Morris Goding  
Access Consulting

Doran Drive Precinct -  
Doran Drive,  
Castle Hill NSW

**Access Review –  
Final v2**

13 July 2021

Dwg No. **DA-110-010**

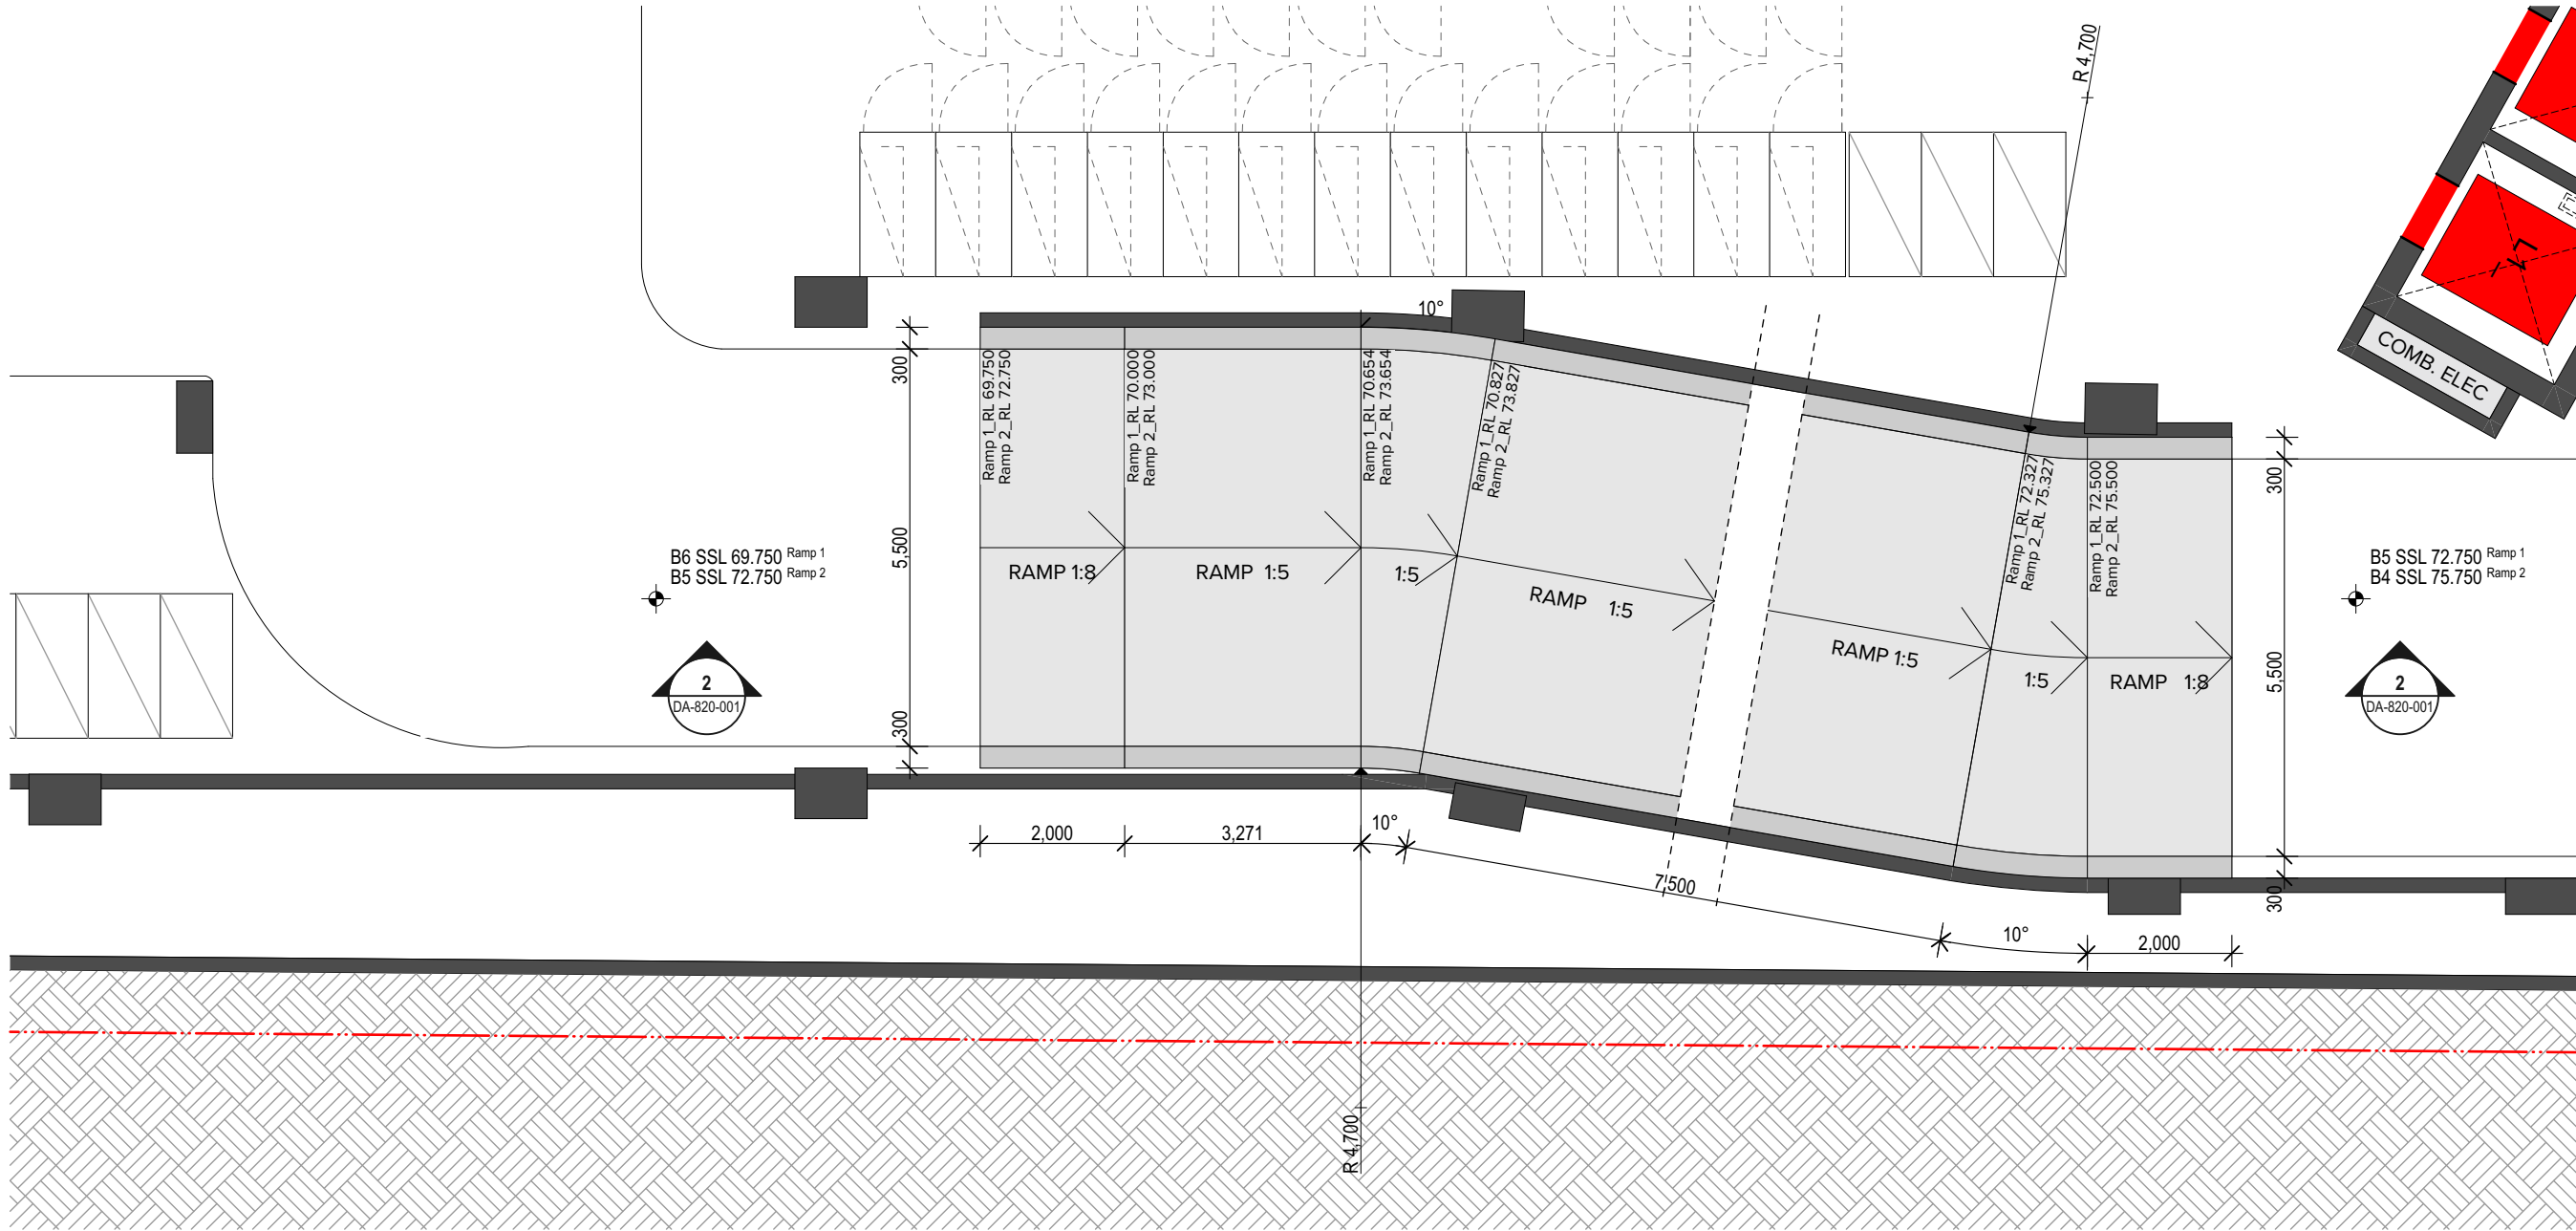
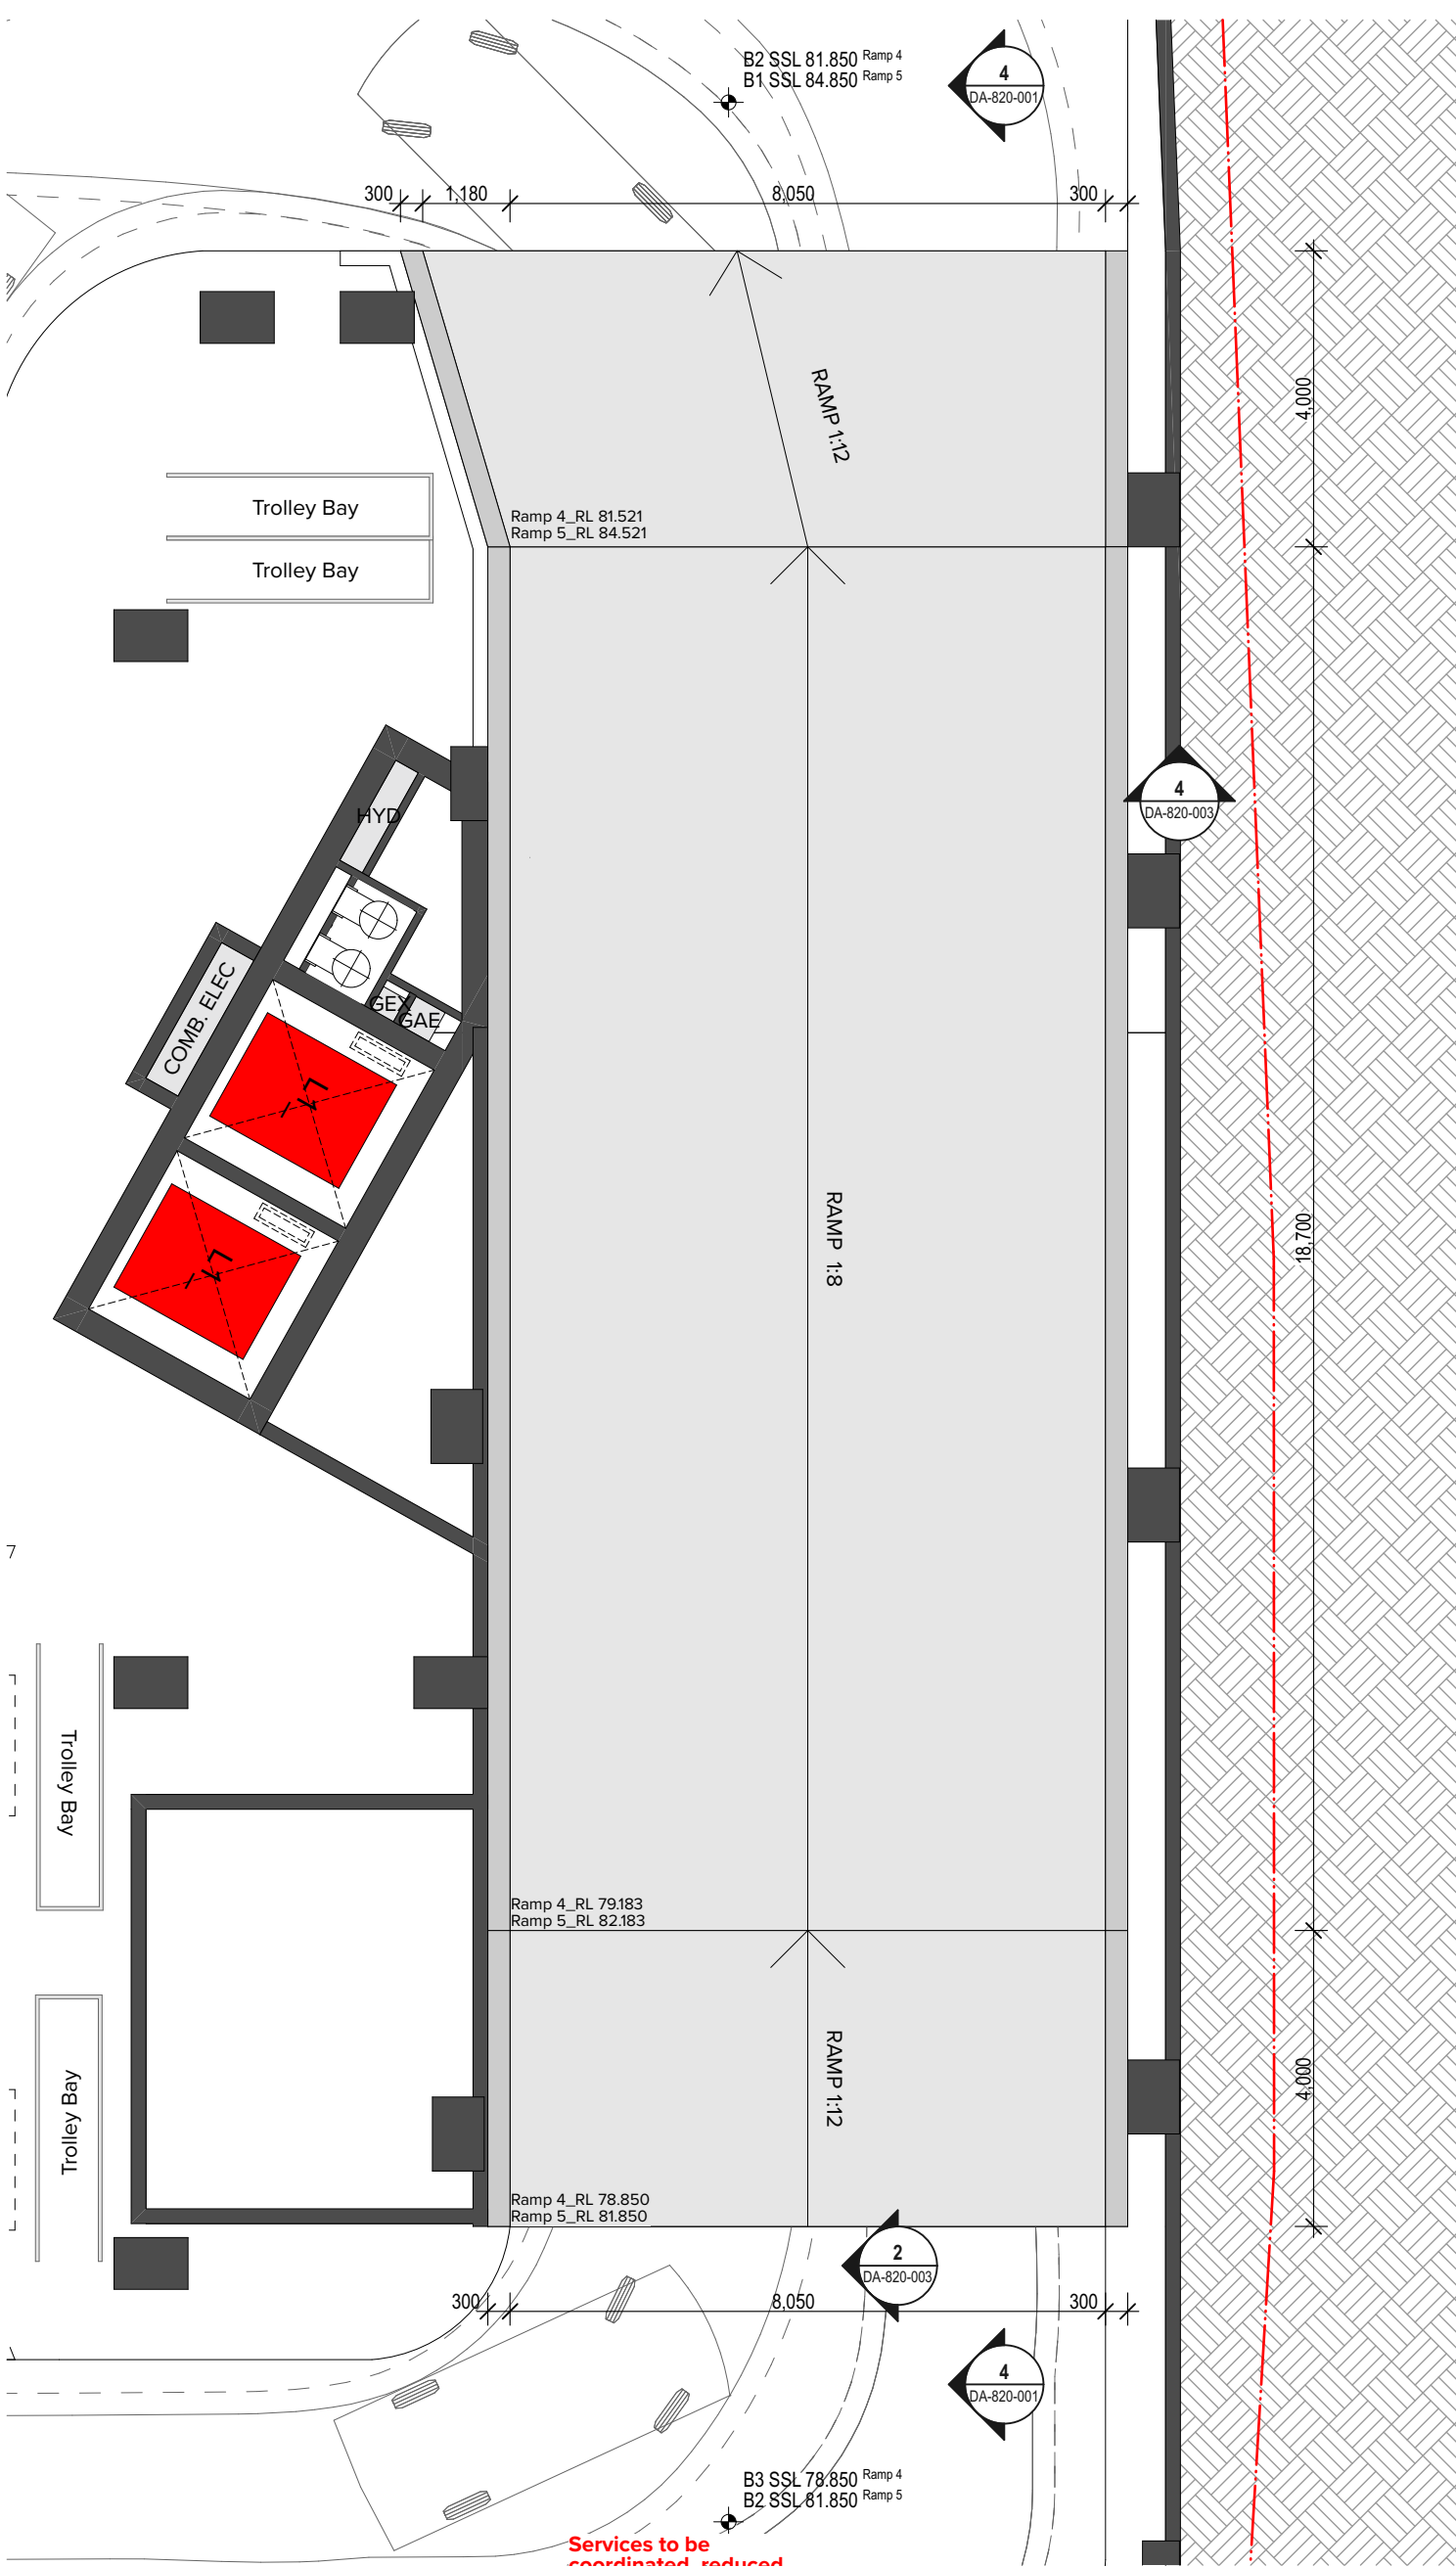
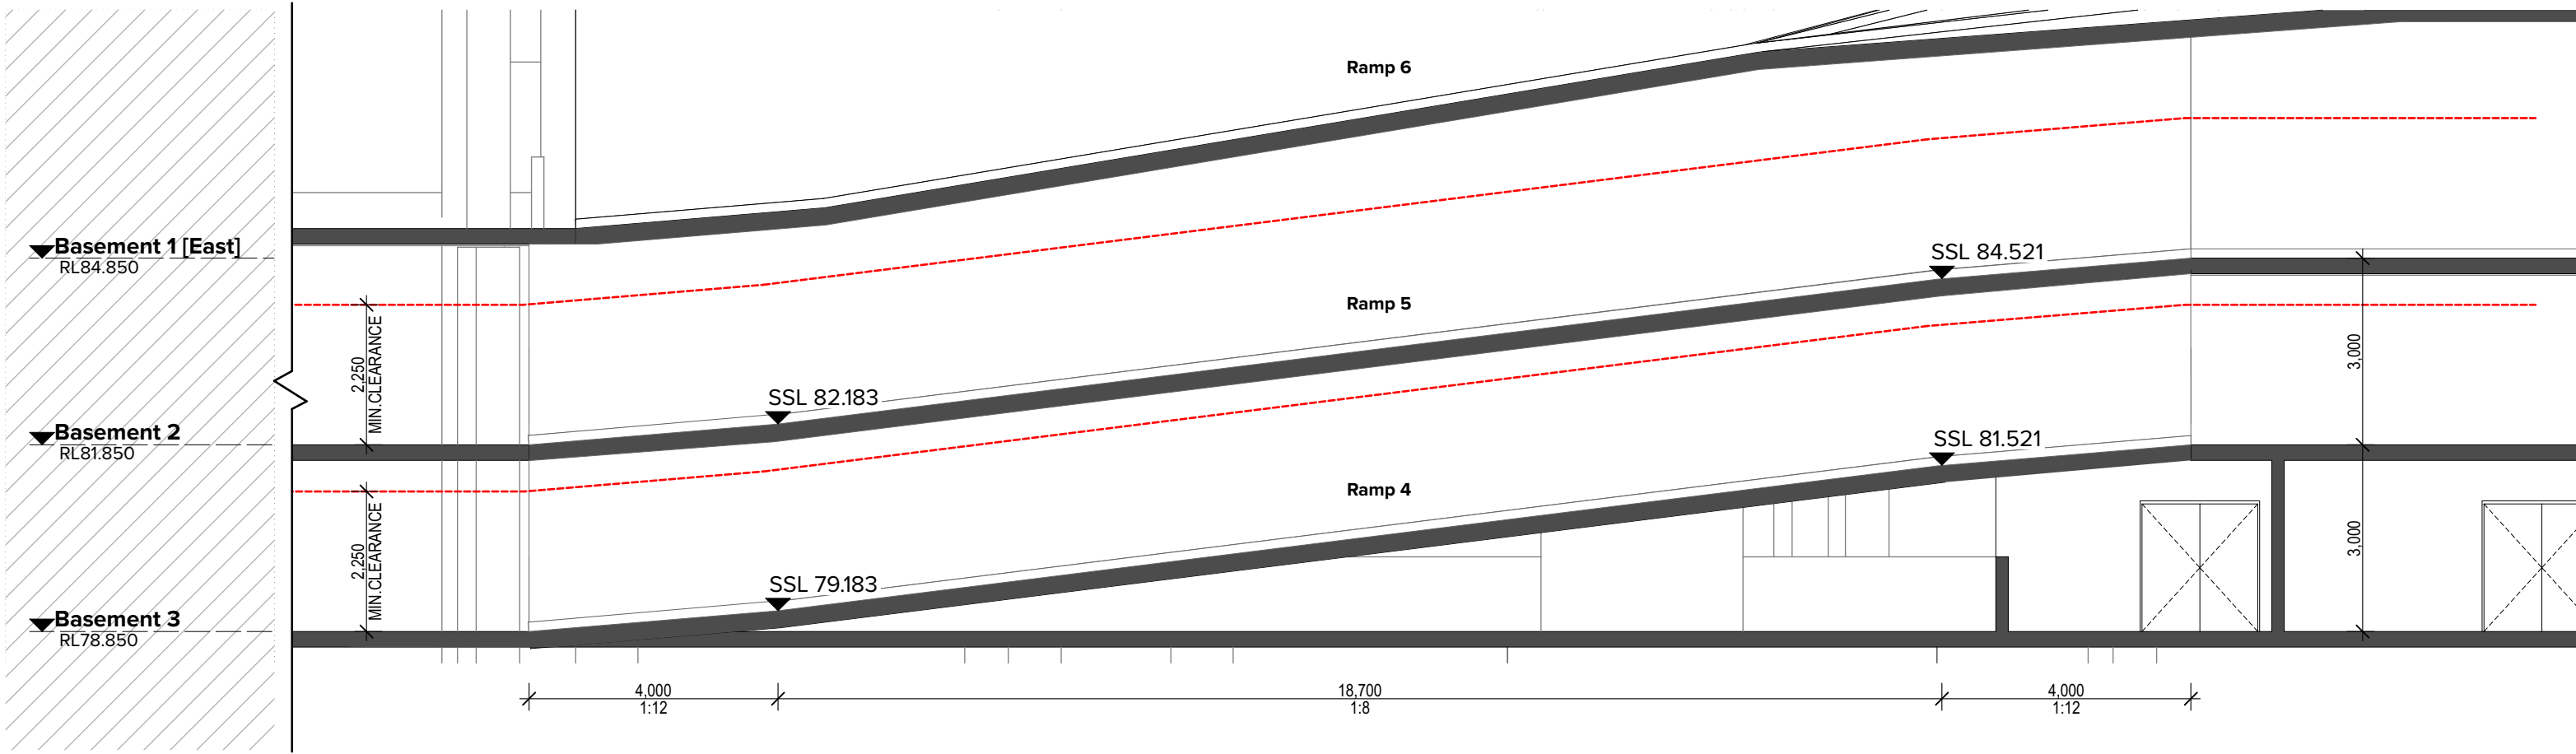
- Ramps and walkway landings are to provide 1200mm length or 1500mm length at 90 degree turns. Currently this requirement is not achieved as the 1:25 Walkway on De Clambe Drive (ground floor) does not provide transitional landing when joining the transversal proposed pathway. Refer to AS1428.1 Fig. 4 and 13. There is sufficient space for amendments to be readily made to achieve compliance during a further stage. Landscaper architect is to ensure compliance in accordance with AS1428.1.

- Step ramps are to have 1:10 gradient, 190mm max. height and 1900mm max. length. Clarification is required as it is not clear whether the gradient or the level difference of the proposed ramp at the entry lobby B (ground floor). Given the adjacent RL's it appears there is a level difference of 75mm to 260mm. The provision of a step ramp outside and inside is recommended to address level differences. Ensure door provides suitable level landing circulations. Ref to AS1428.1 Fig. 25(D).
